**Re: Planning Application 20/0215**

**Address: The Newdrop Stoneygate Lane Ribchester PR3 2XE**

**Description: Conversion of Public House to five dwellings.**

There has been a further submission of plans regarding the parking for the proposed residential dwellings. Plan numbered Job 2991 Drg No 025 Rev C.

Proposed Site Plan  
scale 1:200

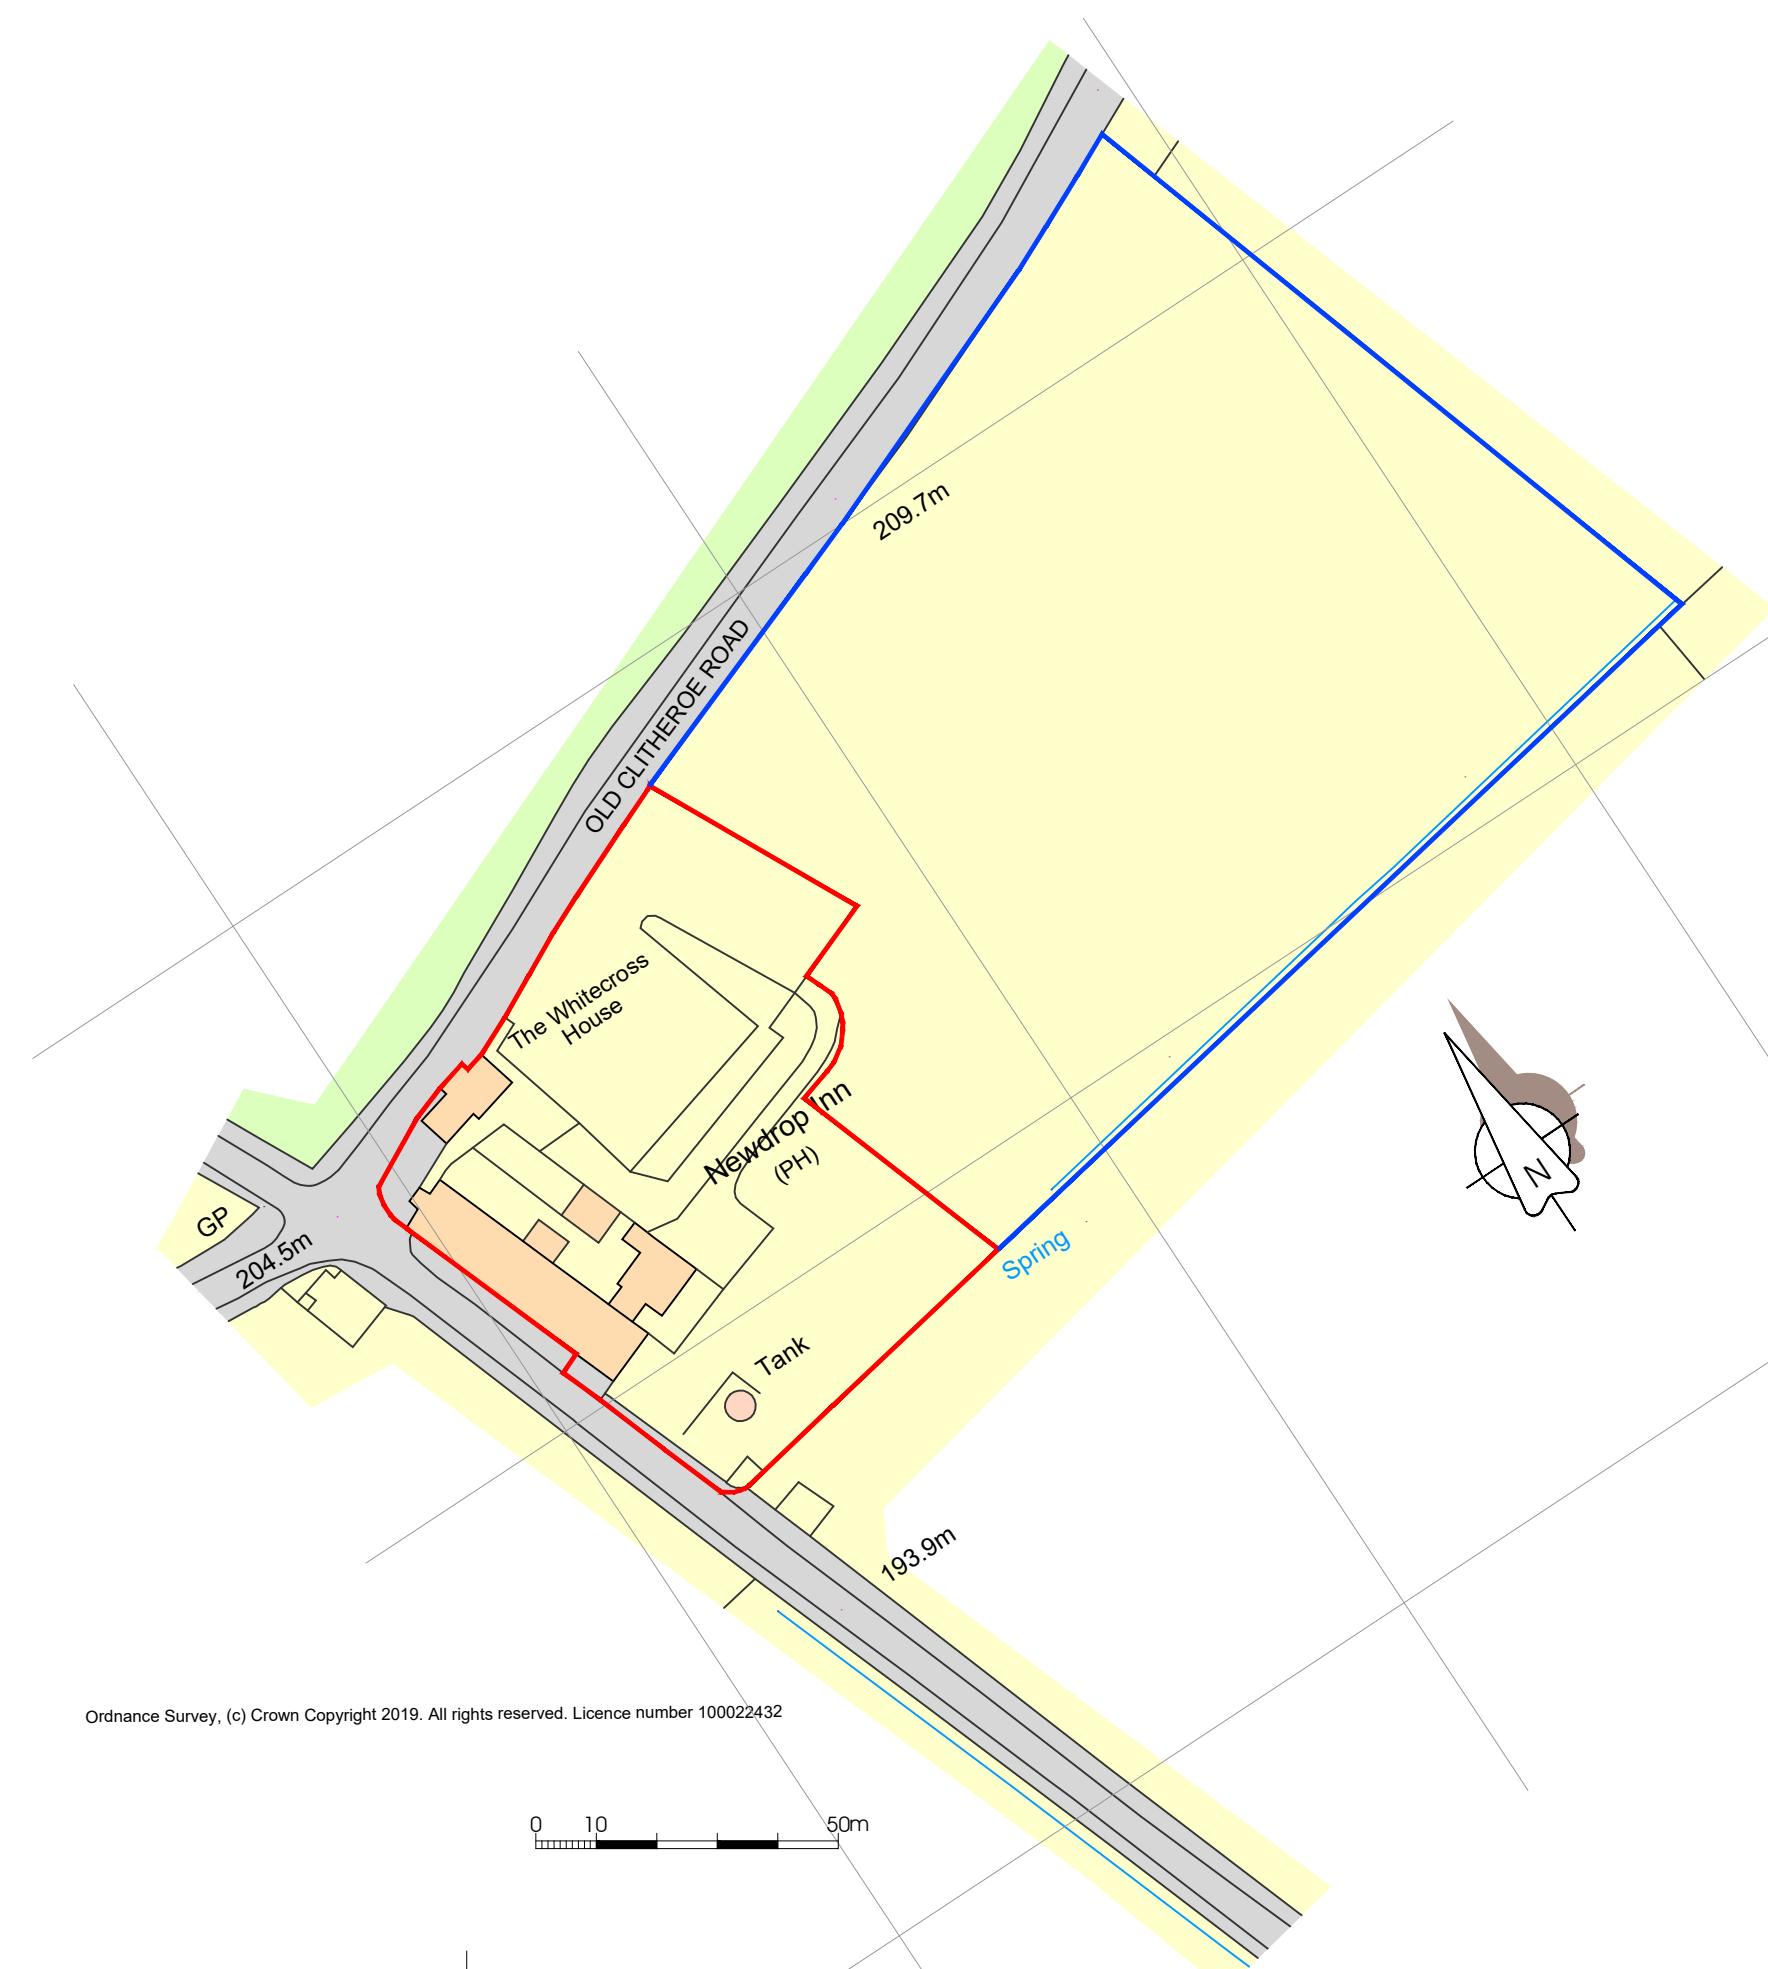
1. All gates and associated mechanisms to be located outside the adopted highway and the gates to have physical restraints to prevent the gates from opening onto the adopted highway. **Reasons** to ensure the adopted highway is not obstructed by the gates or are a hazard to other road users.
2. Before the access is used for vehicular purposes, that part of the access extending from the carriageway boundary for a minimum distance of 5m into the site shall be appropriately paved in tarmacadam, concrete, block pavements, or other approved materials. **Reasons:** To prevent loose surface material from being carried on to the public highway thus causing a potential source of danger to other road users.

3. Before the development hereby permitted becomes operative the visibility splays measuring 2.4 metres back from the edge of the carriageway to the full extent of the curtilage in each direction on Stonegate Lane at the centre of the garage. The land within these splays shall be maintained thereafter, free from obstructions such as walls, fences, trees, hedges, shrubs, ground growth or other structures within the splays in excess of 1.0 metre in height above the height at the centre line of the adjacent carriageway.
